**PR-2024-009917**

SD-2024-00092

**REQUEST:** REPLAT OF 2 EXISTING LOTS

**Project Name:** Tract L-1-B-1-A-1 Atrisco Business Park and Lot 21-A-1 Meridian Business Park

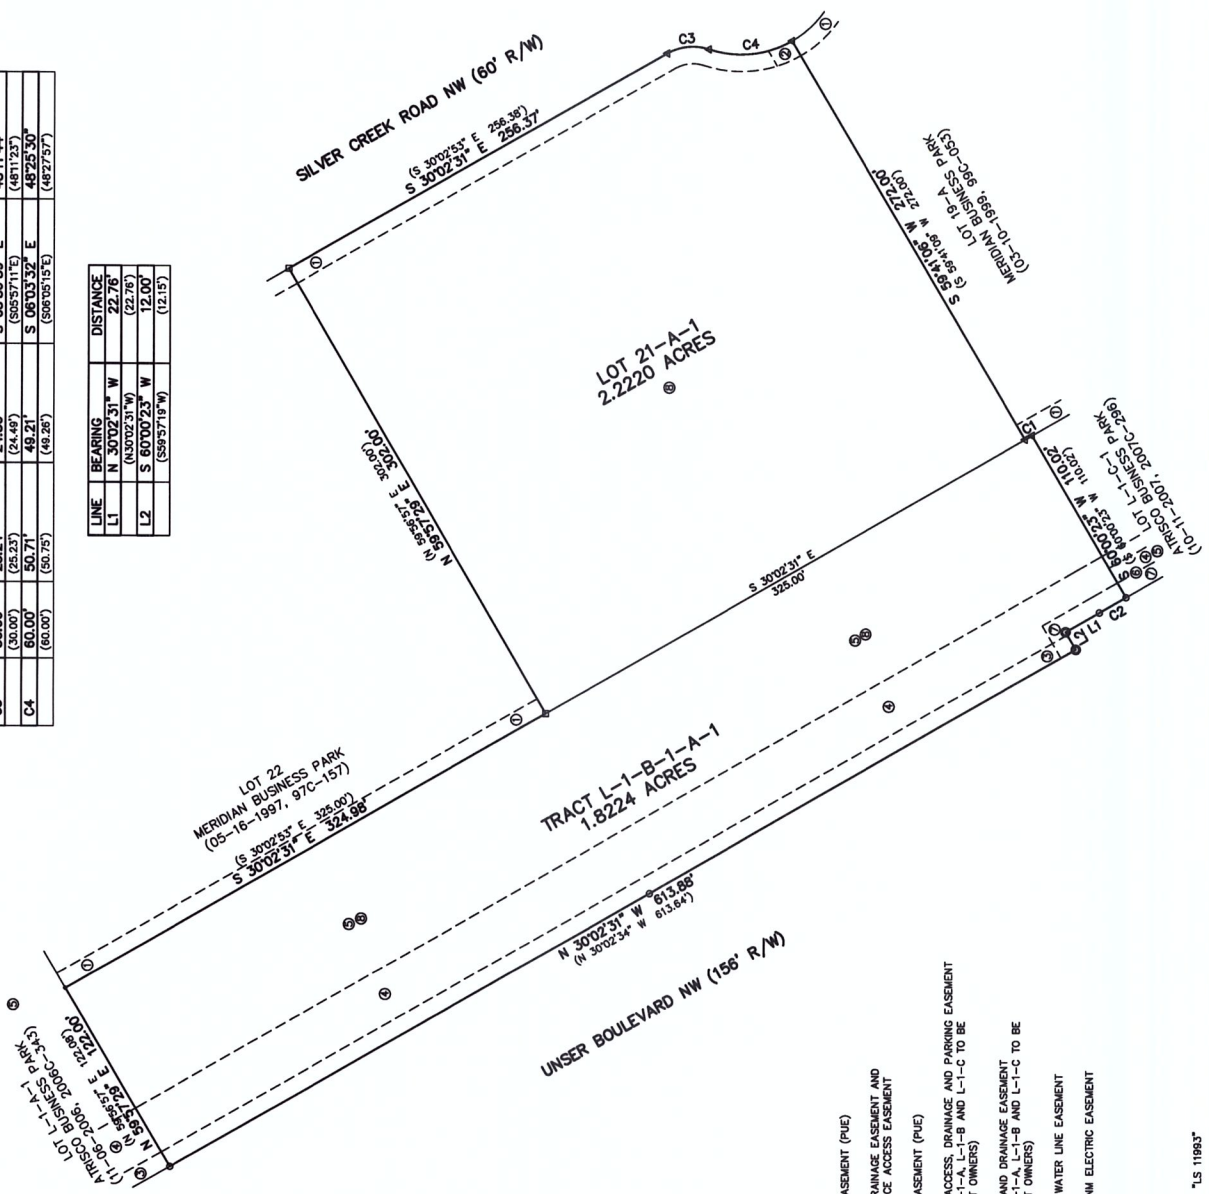
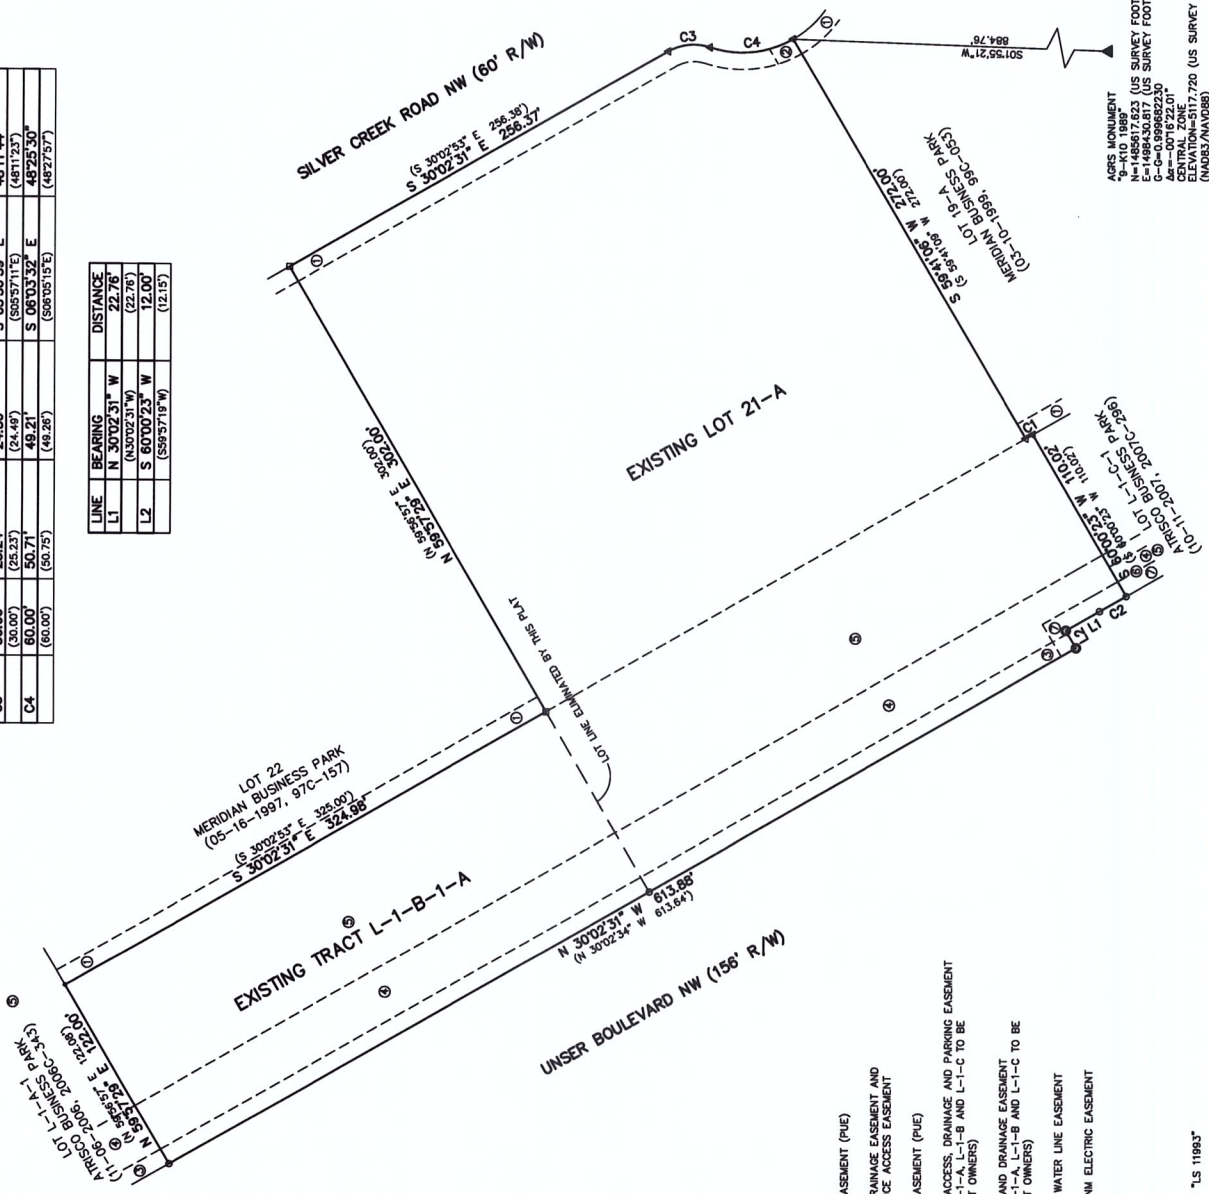
- The Sketch Plat for the proposed replat included a conceptual Site Plan featuring two commercial buildings and improvements largely on Tract L-1-B-1-A-1. However, portions of the proposed parking on the conceptual Site Plan were depicted on Lot 21-A-1; please confirm if future development is proposed on Lot 21-A-1.  
Update – 6/10/23: At the May 22<sup>nd</sup>, 2024 hearing for the application, the Applicant confirmed that a self-storage facility is proposed to be constructed on Lot 21-A-1, and that the proposed self-storage facility would utilize the portion of the parking lot on Lot 21-A-1 along with the proposed commercial development on Tract L-1-B-1-A-1 (for a single-story shopping center in two buildings) that is currently under Building Permit review per BP-2023-47519. Planning staff recommend that the lot line between Tract L-1-B-1-A-1 and Lot 21-A-1 be adjusted to include all required parking for the proposed commercial development on Tract L-1-B-1-A-1, **and require the Applicant provide Plan sheets from the Building Permit application for BP-2023-47519 and/or a parking calculation table(s) confirming the required parking spaces versus provided parking spaces per Section 5.5 of the IDO for the proposed commercial development on Tract L-1-B-1-A-1, and confirm that the parking requirements for the proposed commercial development on Tract L-1-B-1-A-1 are met.**

- Project and application numbers must be added to the Plat sheet.
- Confirm the approval of the existing driveway and curb-cut off of Unser Boulevard.
- DXF File must be approved by AGIS office before final sign-off of this Preliminary/Final Plat request.

- Please note that per the Atrisco Business Park Master Development Plan, properties adjacent to Unser Boulevard shall have a 6-foot wide sidewalk with a minimum 12-feet between the back of curb and the sidewalk. An analysis of the site in Google Street View (see picture below) appears to depict a sidewalk at least 6-feet in width, but the landscape buffer doesn't appear to be a minimum of 12-feet in width between the back of curb and the sidewalk as required by the Atrisco Business Park Master Development Plan.

- In the sidewalk/landscape buffer exhibit, the Applicant also depicts a 5-foot wide sidewalk with a 4-foot side landscape buffer along Silver Creek Road and has placed the infrastructure on an Infrastructure List (IL), addressing Transportation comments from the May 22<sup>nd</sup> DHO meeting. However, the sidewalk along Silver Creek is depicted as being “deferred.” A Temporary Deferral of Sidewalk Construction application would need to be submitted for administrative review and approval to defer sidewalk construction. The forms for this application can be obtained at the following links:

**Update – 6/10/23:** The Applicant has submitted a sidewalk/buffer exhibit confirming a 12-foot-wide concrete trail and a 6-foot-wide landscape buffer between the back of curb along Unser and the sidewalk. Per 2-5(B)(3)(g)(2) of the IDO, a Variance from Master Development Standards may be granted pursuant to the same thresholds and procedures as established by 6-6(P) of the IDO, which permits the DHO to approve a Determination from the landscape buffer requirement provided the justification criteria per 6-6(P)(3) of the IDO are determined to be met. Therefore, a DHO Determination letter for the landscape buffer along Unser must be submitted.
